Site Address: Shepherds Cottage 231 Poling Street Poling BN18 9PU

Description of Works: Demolish rear lobby single storey extension, extend with rear single storey extension and provide a utility room internally.
This application affects the setting of Poling Conservation Area

**ADC Planning Consultation
Response from the Historic Buildings Adviser**

Application Number	PO/2/13 & PO/3/13/L
Address	Shepherds Cottage, 231 Poling Street, Poling, BN18 9PU.
Description	Application for Listed Building Consent to demolish rear lobby single storey extension, extend with rear single storey extension and provide a utility room internally.
Case Officer	Damian Sullivan
Site Visit	Previous

EXISTING & PROPOSED
ELEVATIONS

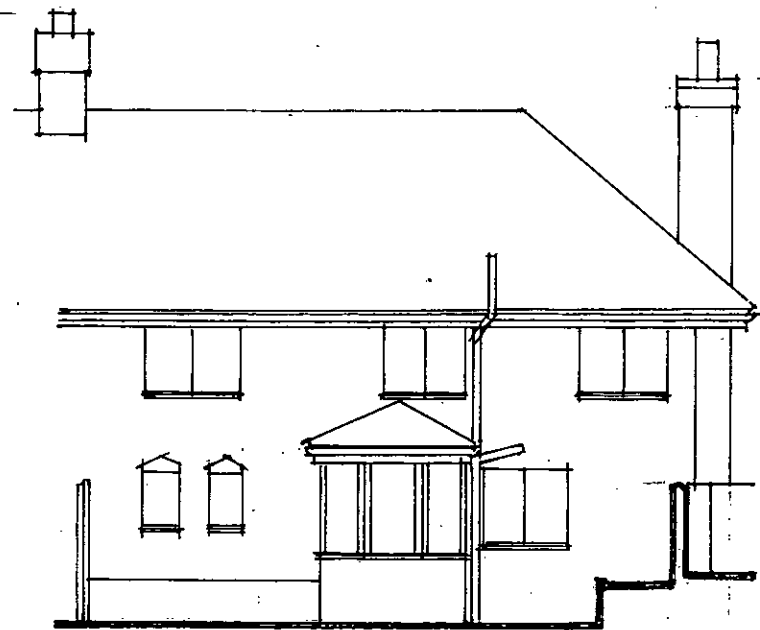
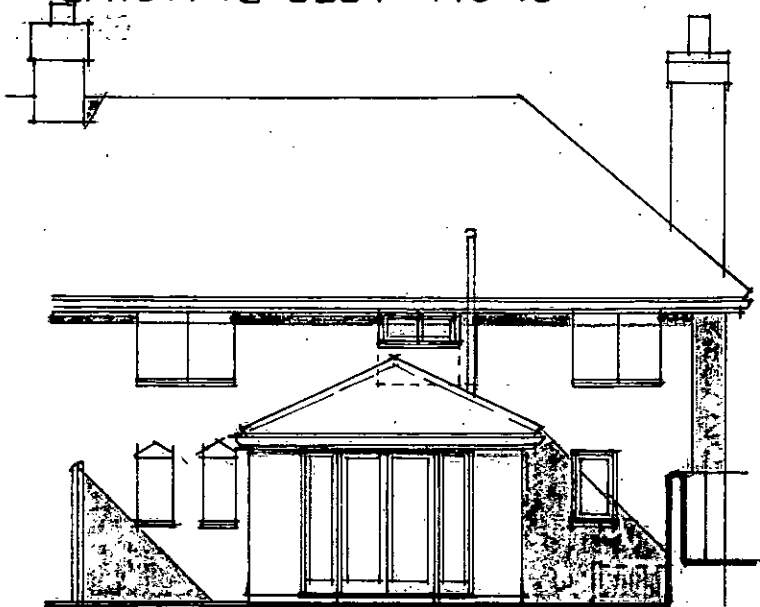
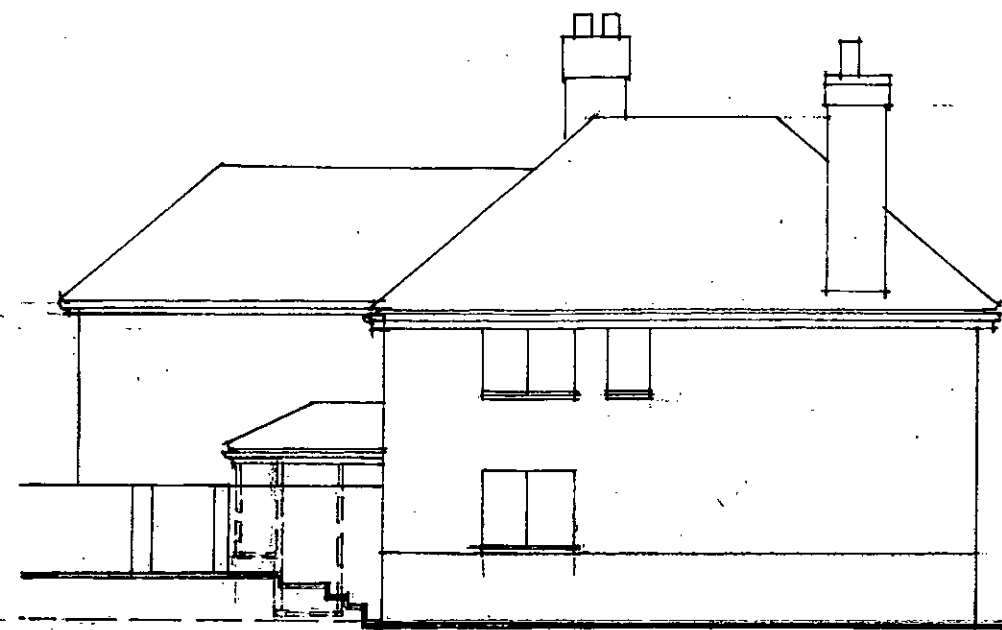
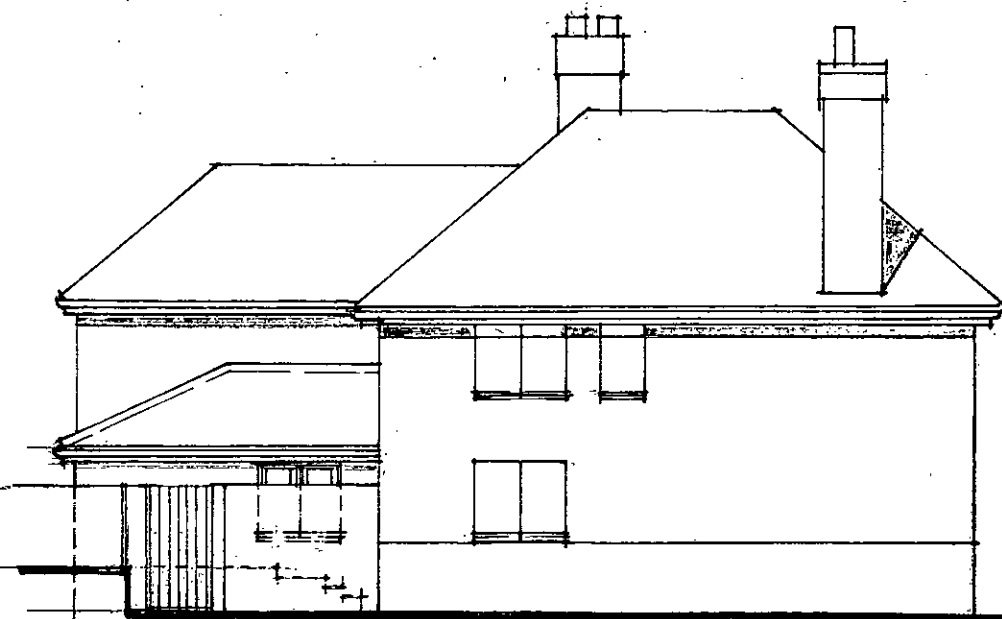
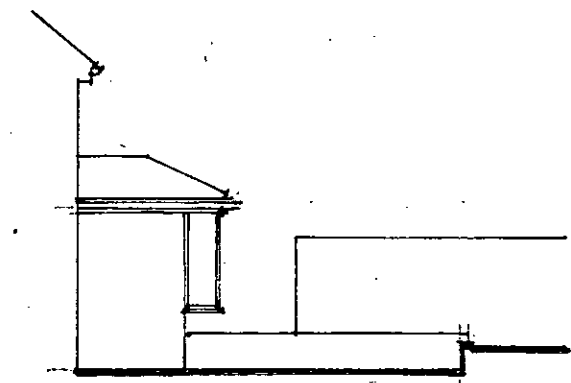
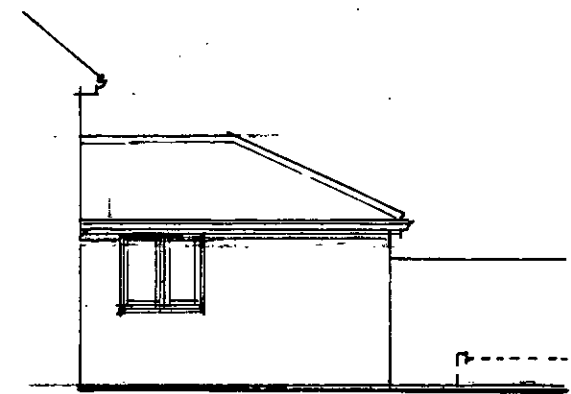
Whilst the alteration to the first floor window is not particularly sympathetic, the scheme can be largely supported on the basis that the existing addition is of poor quality and this scheme should prove to be an enhancement.

- Door and window details.
- Materials, especially the roof tiles.
